M. David Blakely Architect Inc.

March 1st, 2016

Re: 64 Cleopatra Dr.
Application for Site Plan Control Approval

DRAWING TITLE: SITE & LANDSCAPING PLAN

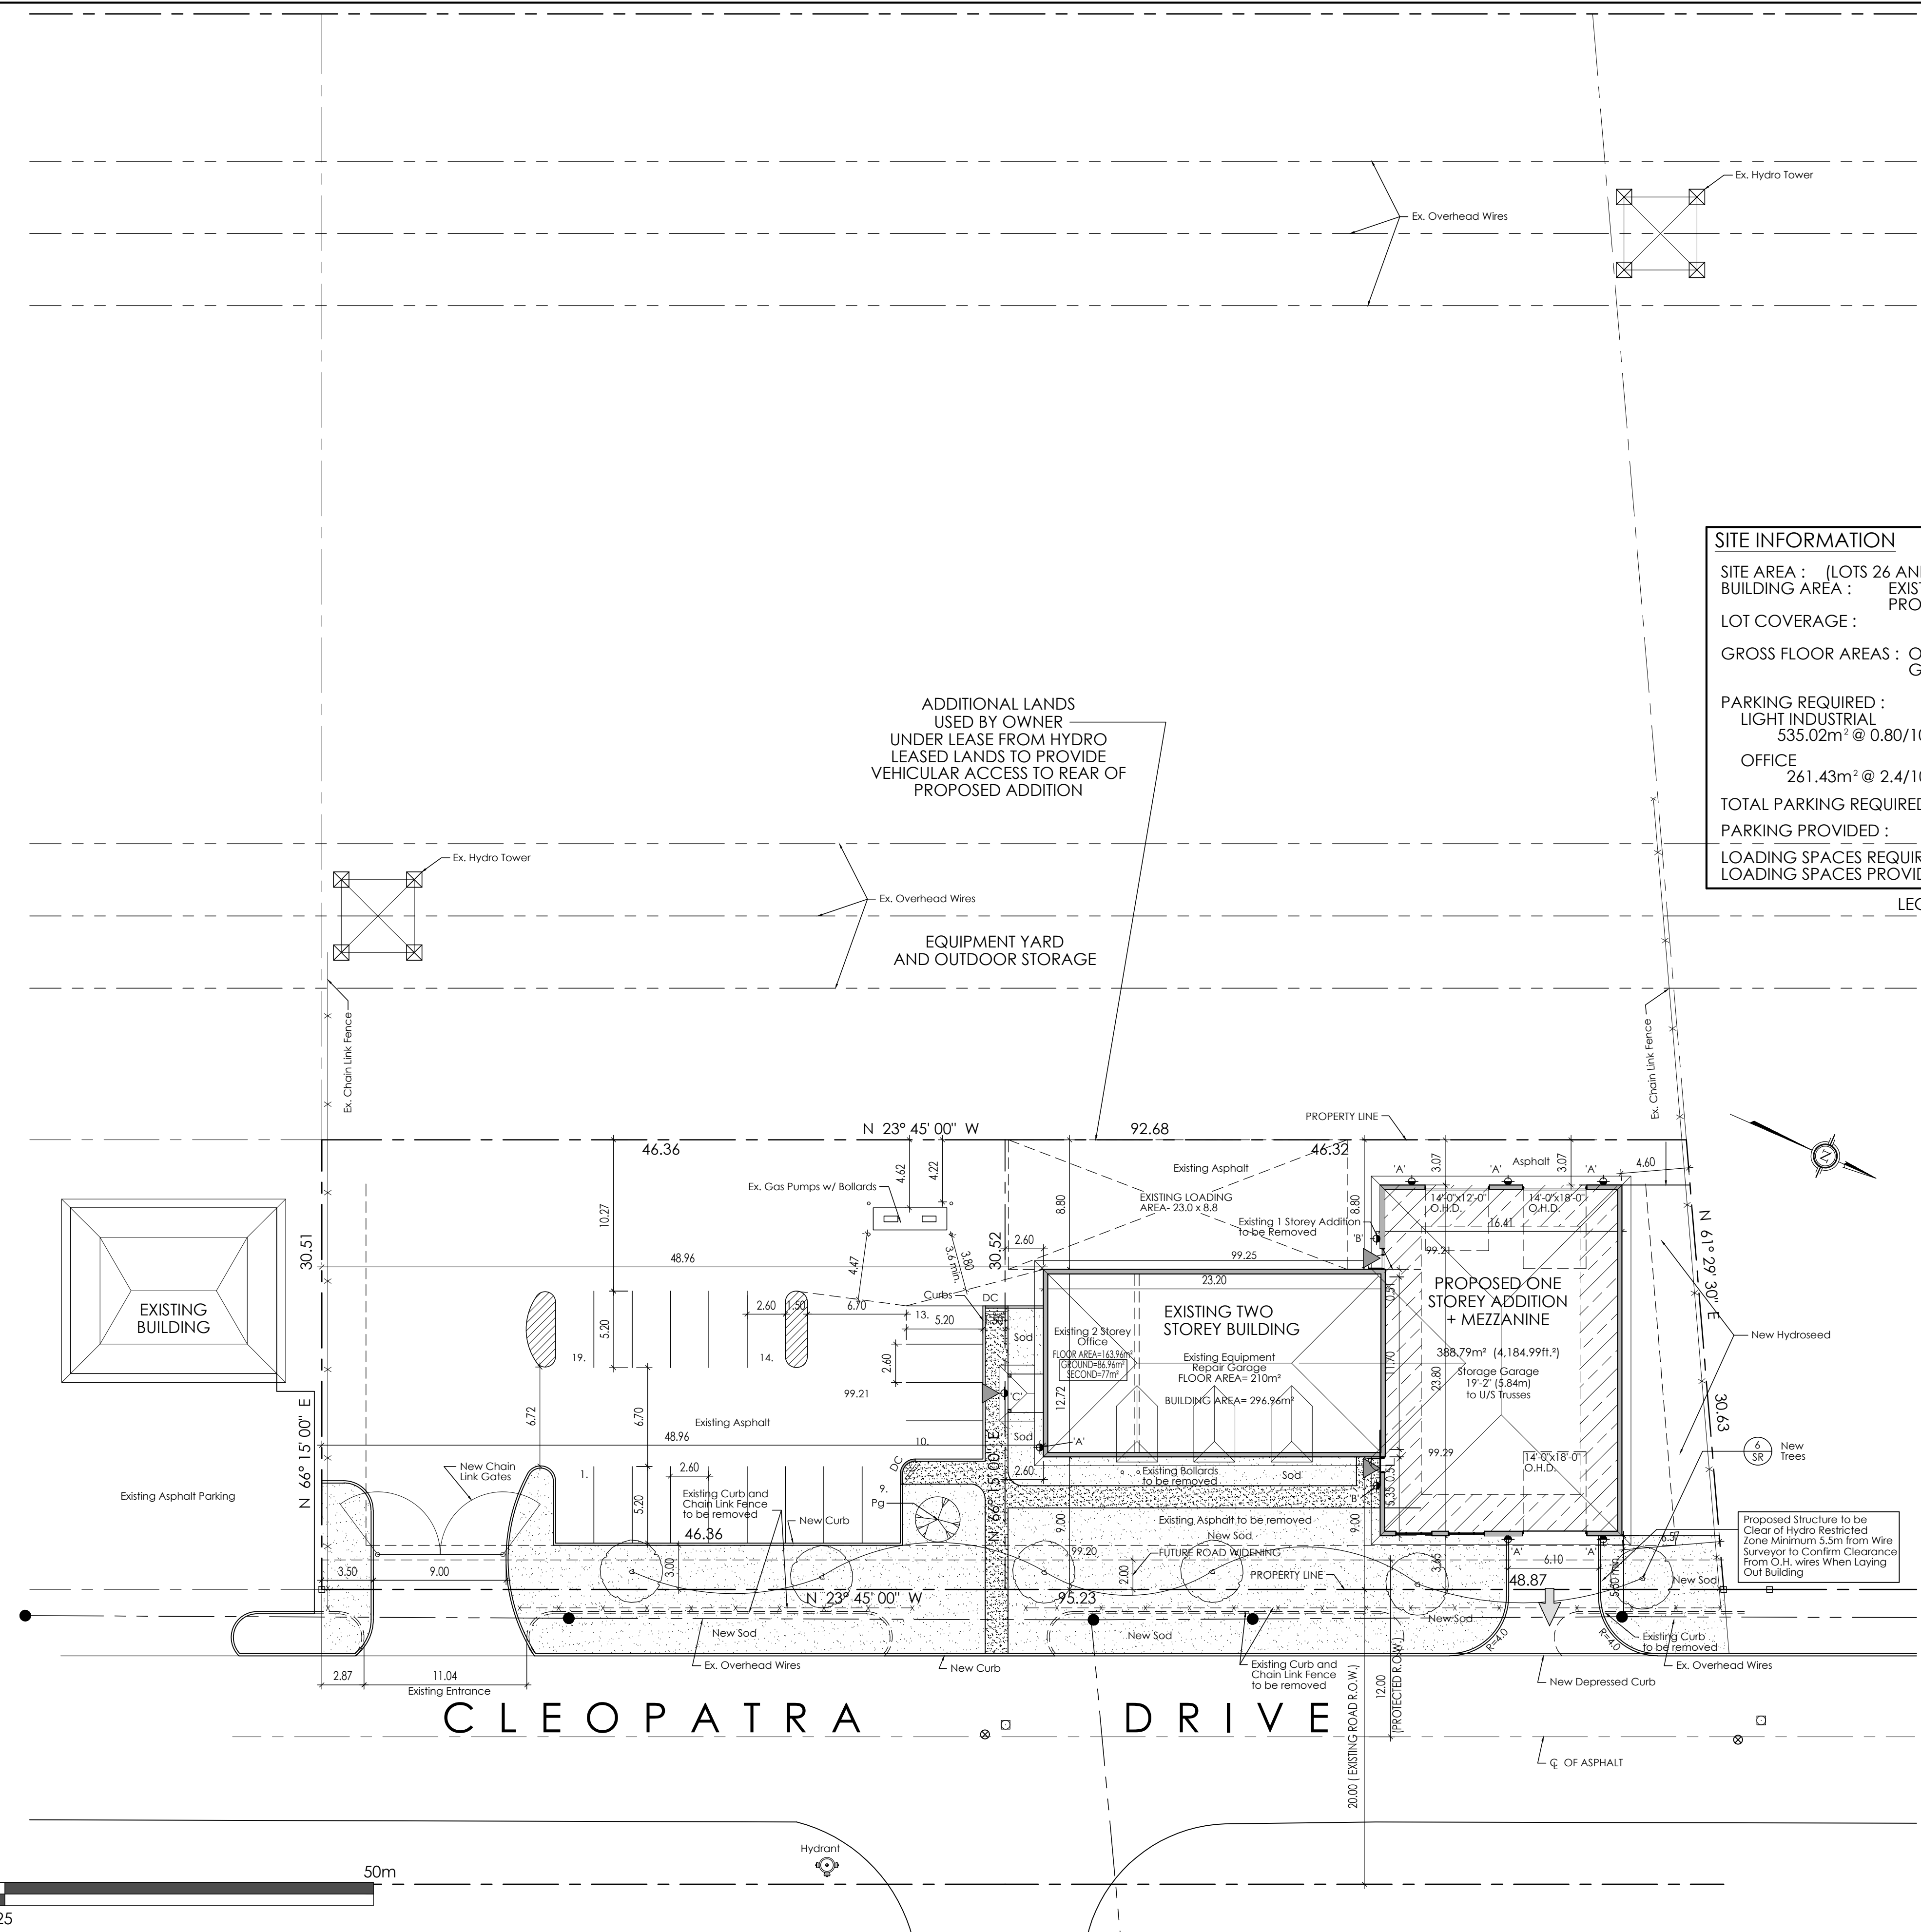
- Will there be new bollards or armour stones along the front property line to secure the site? This would be preferable to continuous fencing. I note the existing ones to be removed.
No bollards, armour stone or fence are proposed to secure the site. Only chain link gates at parking entrance.

- Extend the new sidewalk to the Cleopatra curb.
Sidewalk has been extended to Cleopatra Dr.
- Is the door for the addition to provide 1-way access only? I believe vehicles will enter the addition from the site, and the door along Cleopatra is an exit only, please confirm.
Correct. Directional traffic flow arrow has been added to Site Plan.

- Include depressed curbs from the parking area to the new sidewalks.
Depressed Curbs noted on Site Plan.
- The six new trees are great, would a mix of deciduous and coniferous be something to explore or a mix of species.
We prefer to keep only one species to differentiate the site from adjacent properties.
